CITY OF ALBUQUERQUE

March 23, 2023

RE: **Lot 19 Block 8 Volcano Cliffs Unit 5 SAD 227**
6823 Urraca NW
Grading and Drainage Plan
Engineers Stamp Date: 9/6/2021 (D10D024)
CO Certification Date: 2/15/2023

ENGINEER'S SEAL 	6823 RIMROCK GRADING AND DRAINAGE PLAN Rio Grande Engineering 1606 CENTRAL AVENUE SE SUITE 201 ALBUQUERQUE, NM 87106 (505) 872-0999	DRAWN BY WCVJ DATE 9-02-21 210210083-LAYOUT-B-02-21 SHEET # JOB # 21021083
---------------------	---	--

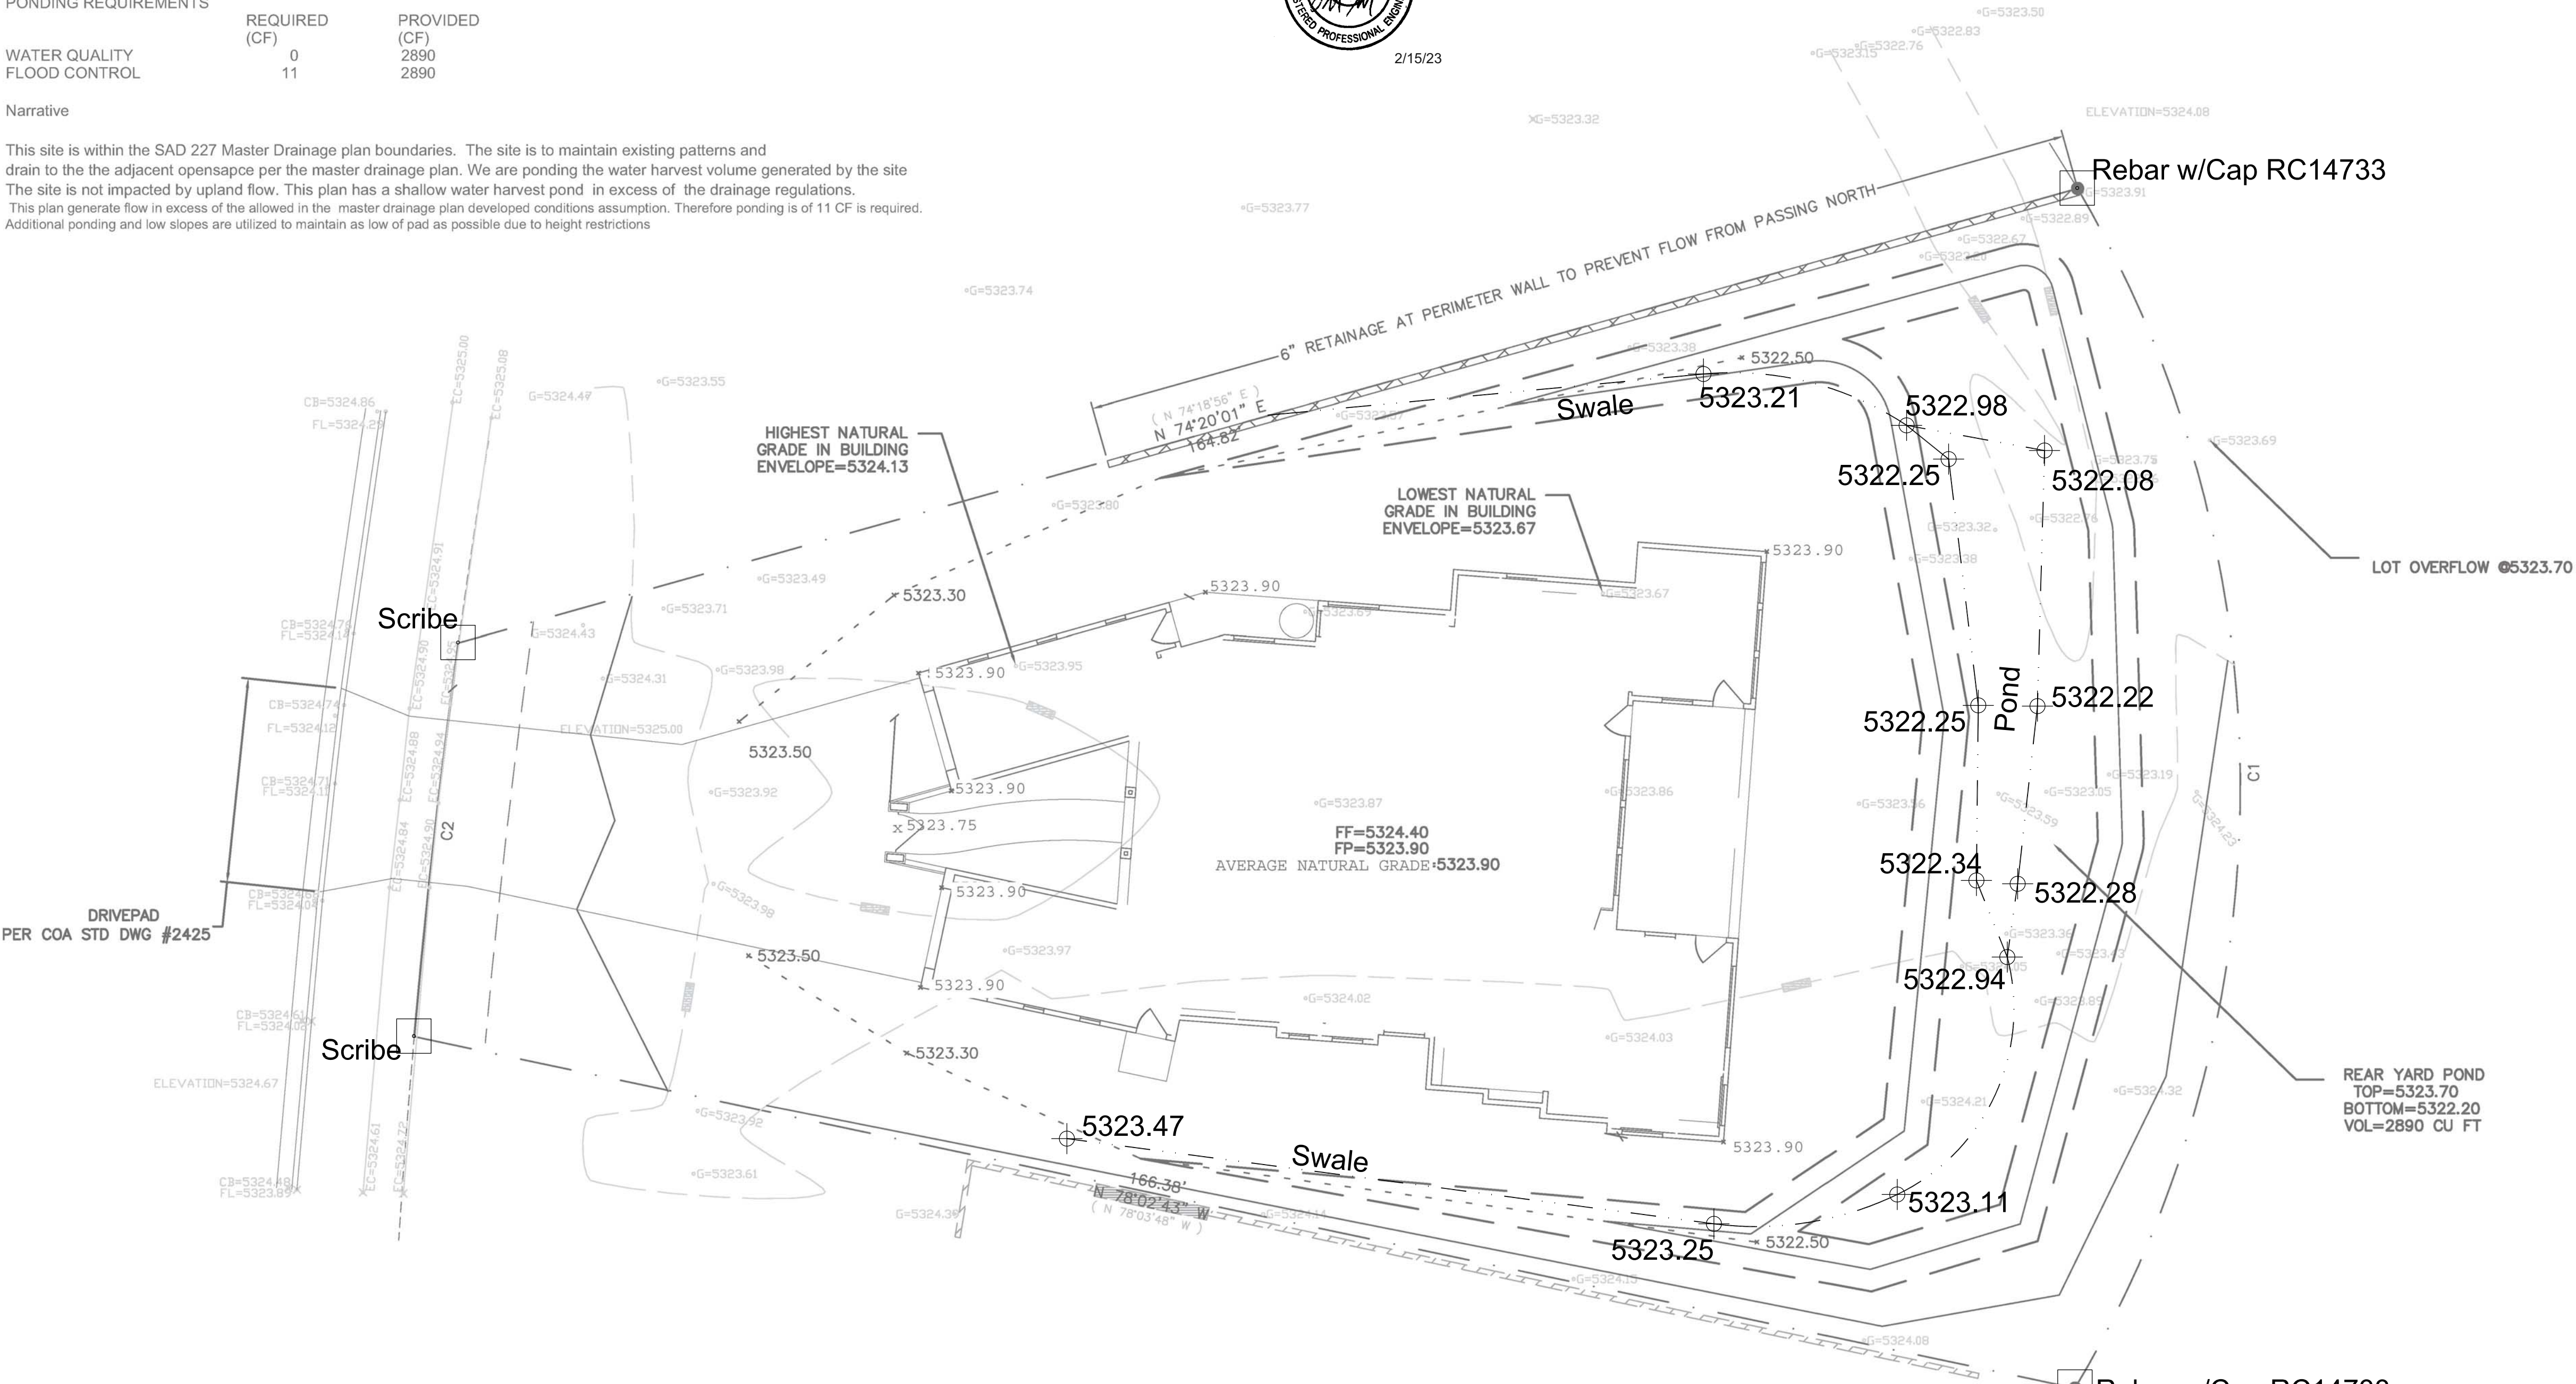
- Ponds must be filled with some type of gravel.
